OXFORDSHIRE COUNTY COUNCIL'S RESPONSE TO CONSULTATION ON THE FOLLOWING DEVELOPMENT PROPOSAL

Application no: 22/01682/F

Proposal: Development of a ground mounted solar farm incorporating the installation of solar PV panels, associated infrastructure and access, as well as landscape planting and designated ecological enhancement areas.

Location: Land North Of Manor Farm, Noke

Visibility Splays at Proposed Site Access

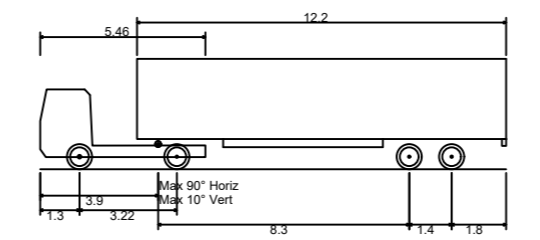
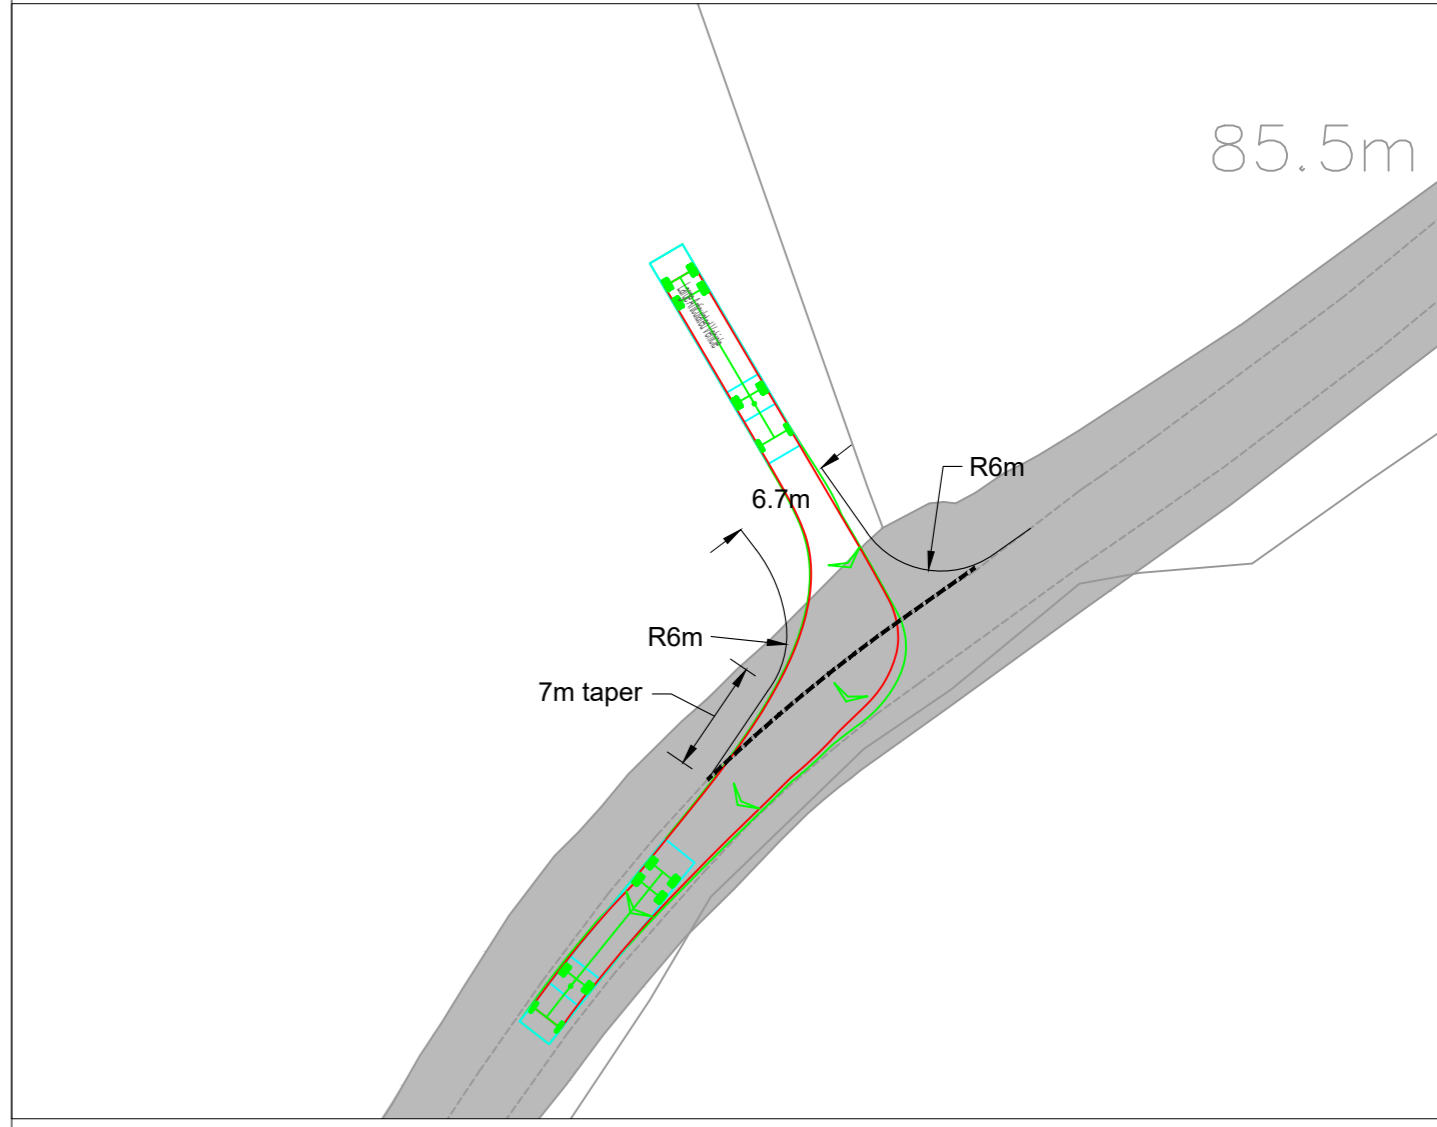
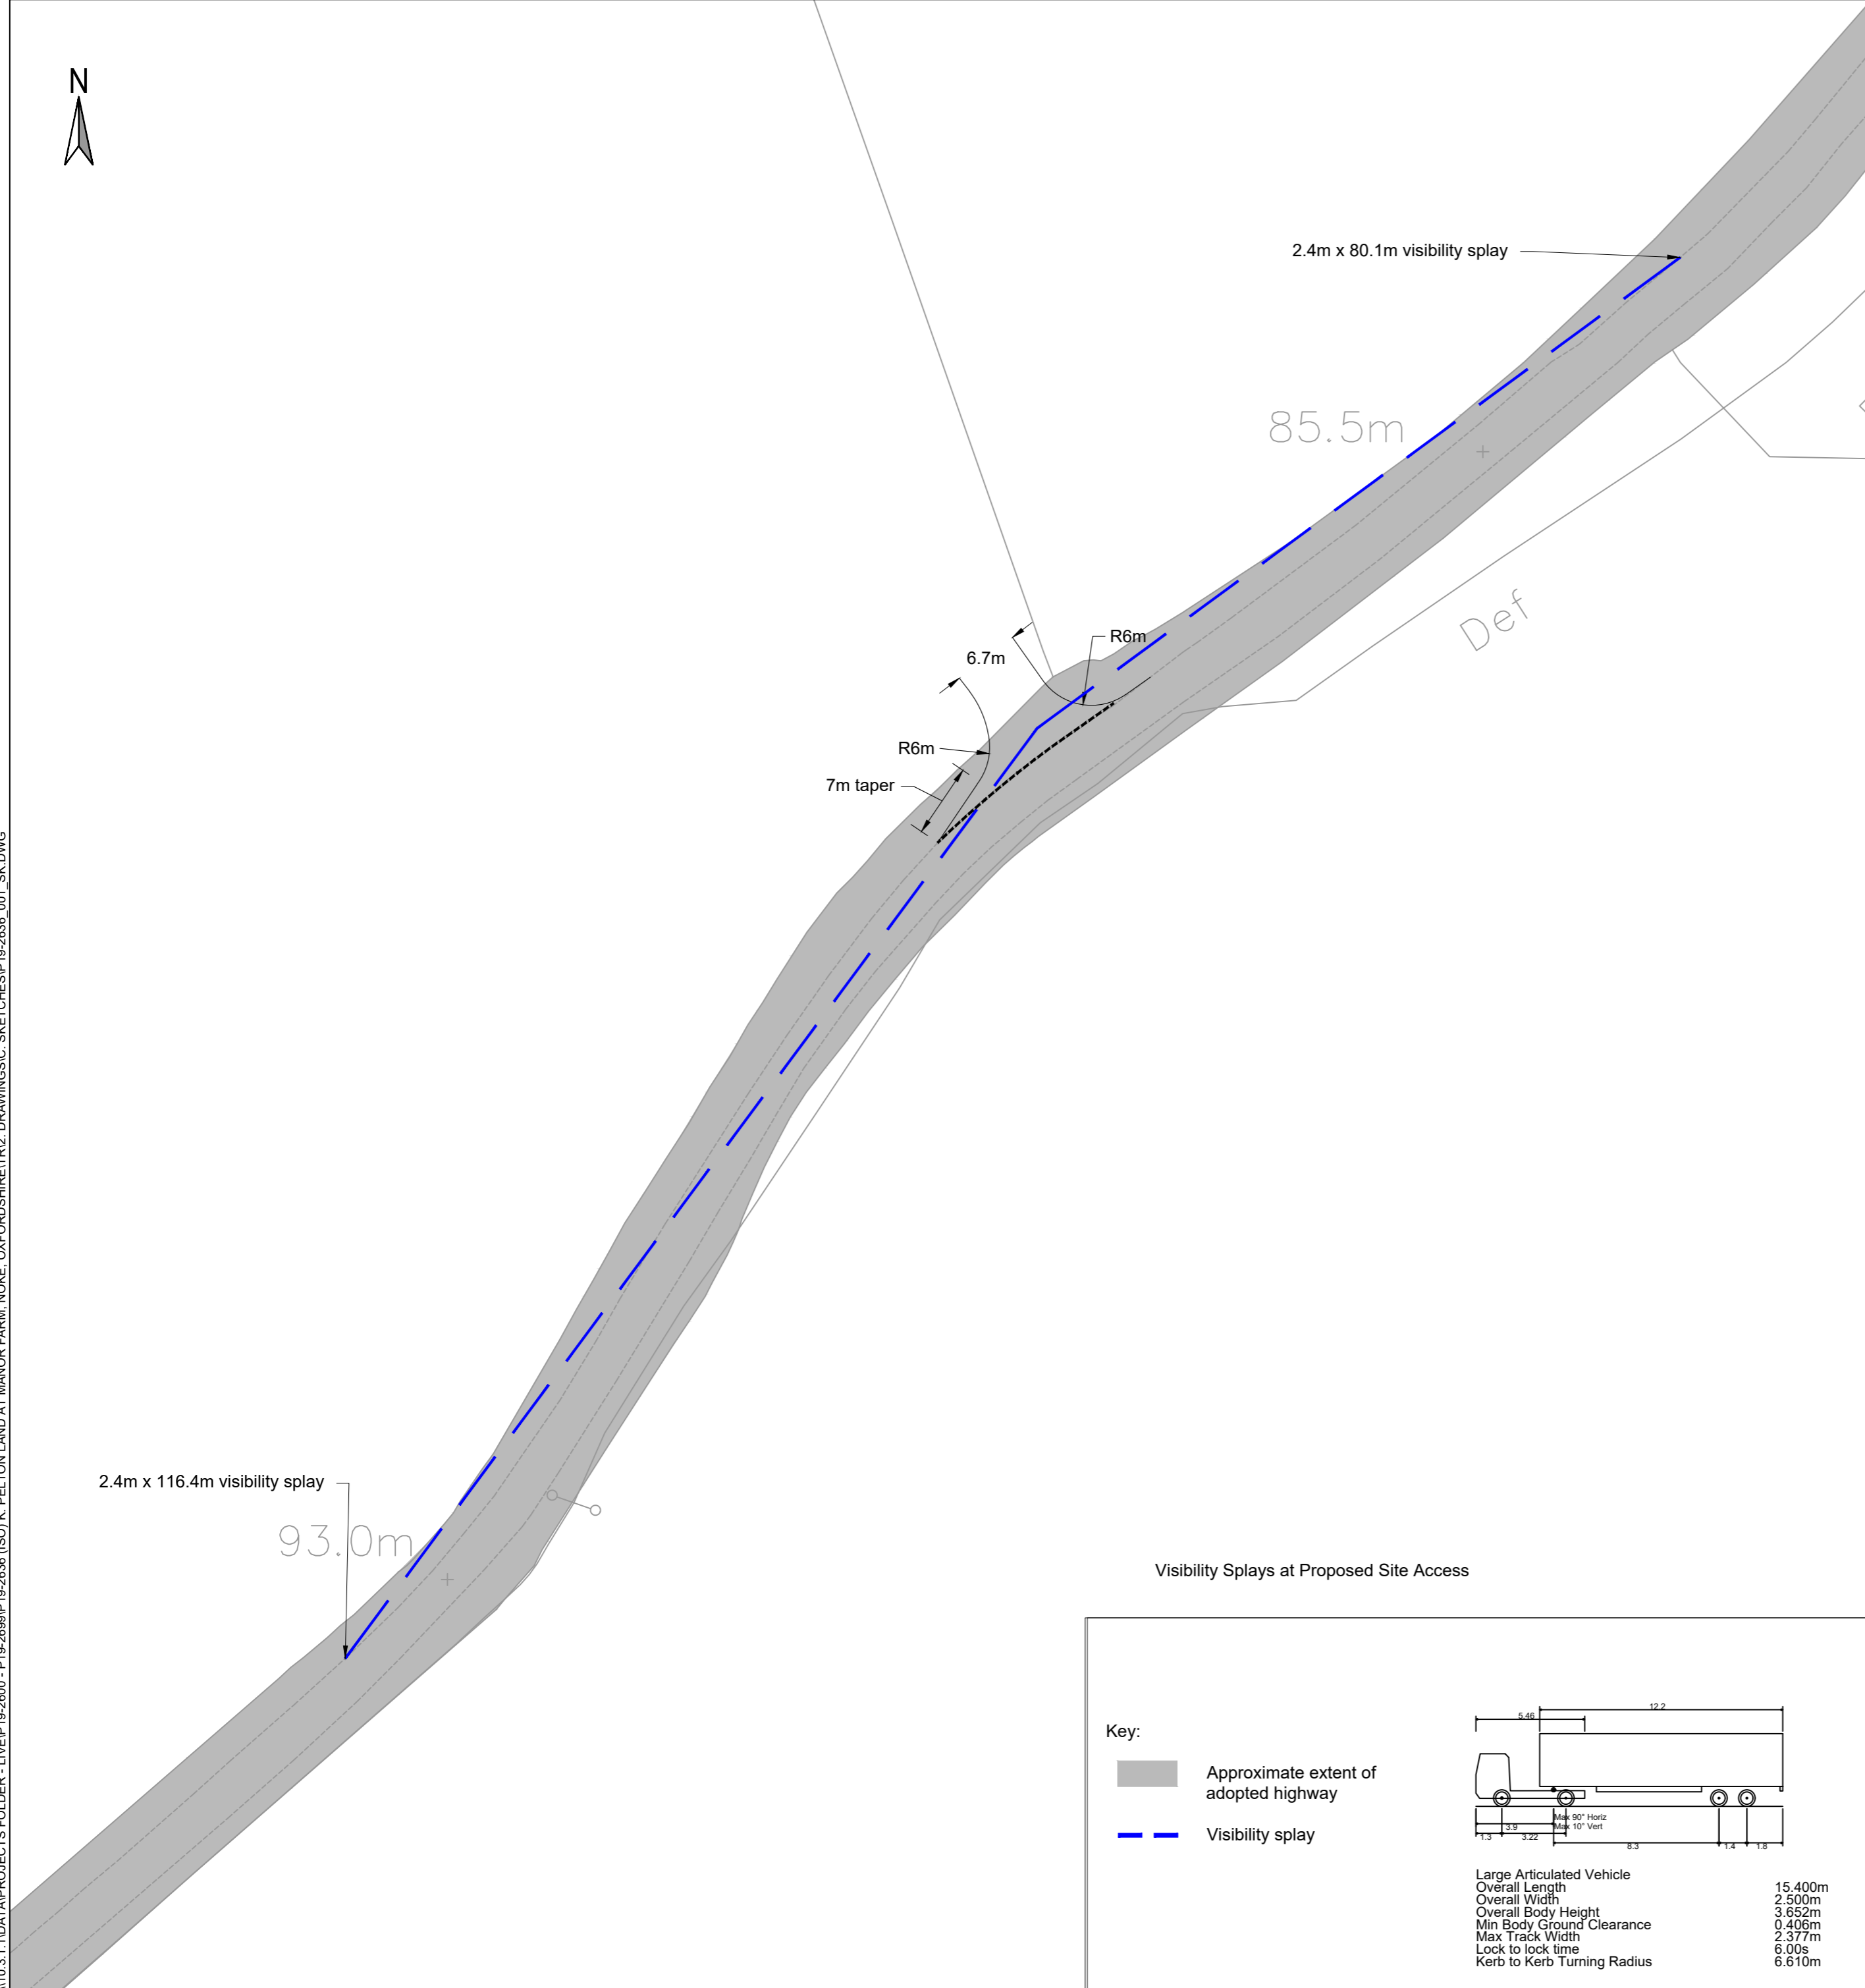
It is not clear which Automatic Traffic Counter is on which side of the access. However, the data from each is very similar so this does not matter in determining the visibility requirements.

The Five Day Average 85thile speeds in Table 2.1 are given for certain time periods. Given that the speeds are unlikely to vary markedly across the day, the 24-hour value

should be used and quoted for both sites separately. For Site 01 these are 30mph (n/b) and 32mph (s/b), and for Site 02 30mph and 33mph. The DMRB visibility requirement for 33mph is 76m, which is less than that available, so I am happy that the access is suitable.
